Re: **Framing Items**
Location: Lot 49 Prince Place (Fuquay-Varina, NC)
JDS Project No.: RDU2311636
Date of Inspection: 12/5/23

A representative of JDS Consulting arrived on site to observe the issues reported to us by the client, which are presented, along with our recommendations, in this report.

S-3a  
SECOND FLOOR FRAMING PLAN

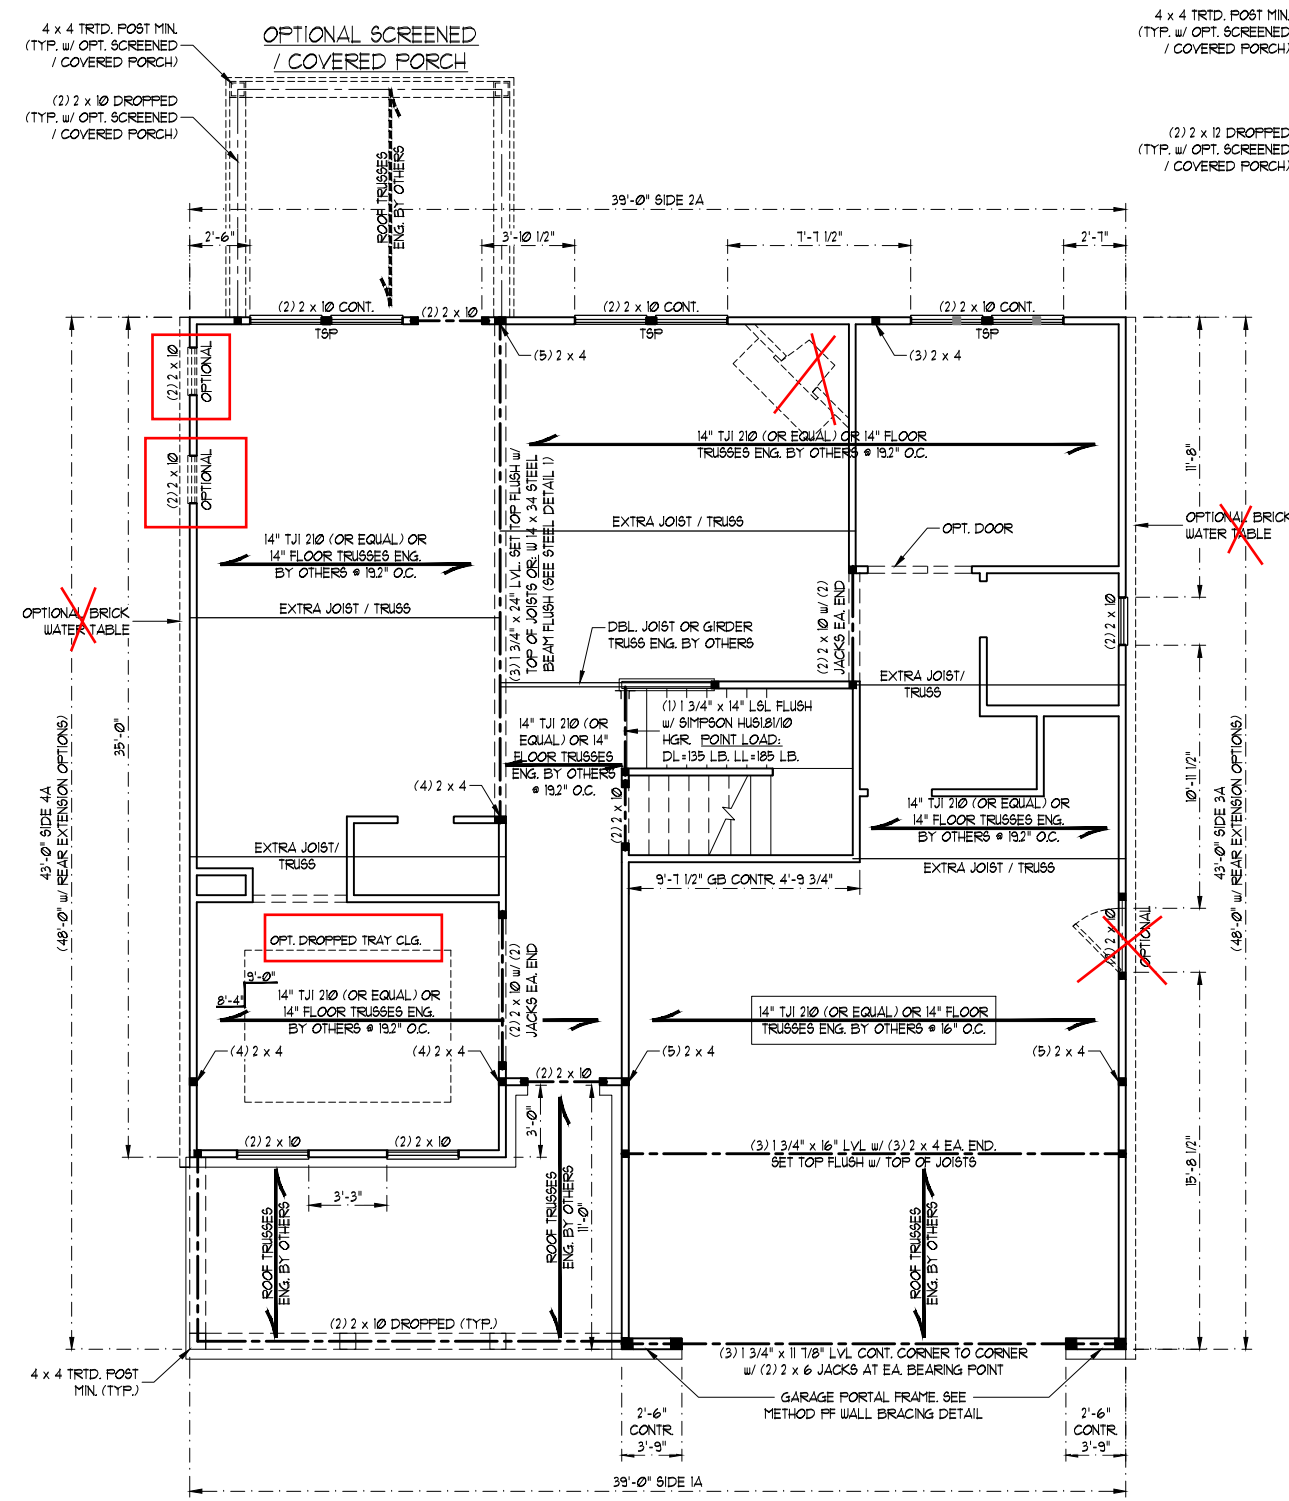
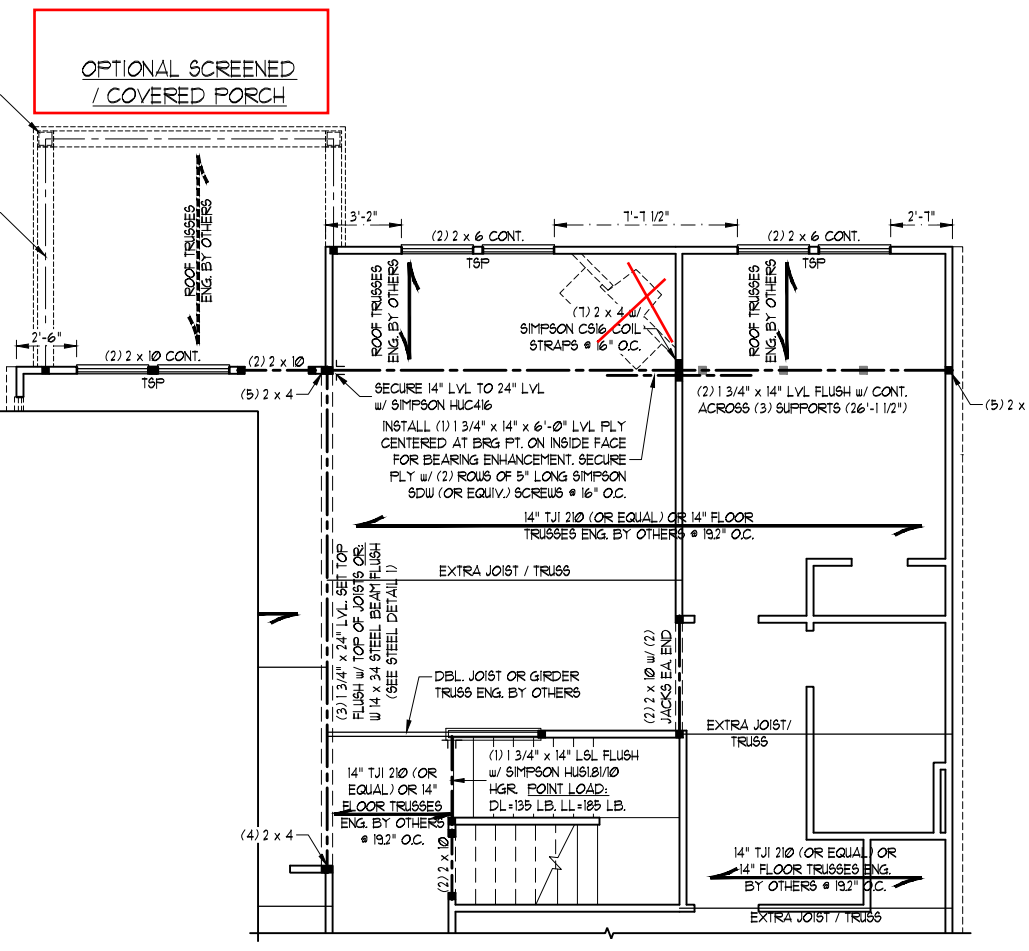
The client has requested evaluation of the contractor not installing the HUC416 hanger at the left bearing end of the (2) ply 1 3/4" x 14" LVL where it called to hanger to the (2) 1 3/4" x 24" LVL. The (2) 1 3/4" x 24" LVL has a double 2x8 nailer just to the rear of it.

Based on our onsite observation and review the contractor shall first attach the double 2x8 nailer to the (2) 1 3/4" x 24" LVL with (2) rows of 6" SDS screws 6" O.C. Then notch the 7/16" sheathing on the rear side of the (2) 1 3/4" x 14" LVL as needed to install (1) Simpson HHUS410 hanger at the left bearing end. Attach the hanger on the rear side of the (2) 1 3/4" x 14" LVL to the double 2x8 nailer and ensure all flange nails are installed per the hanger's manufacturers specifications. Lastly install a 2nd full height 2x4 wall stud directly under the 2x8 to properly carry the load to the sill plate. Ensure there is a (2) 2x4 column below the above-mentioned column to carry the load to the foundation.
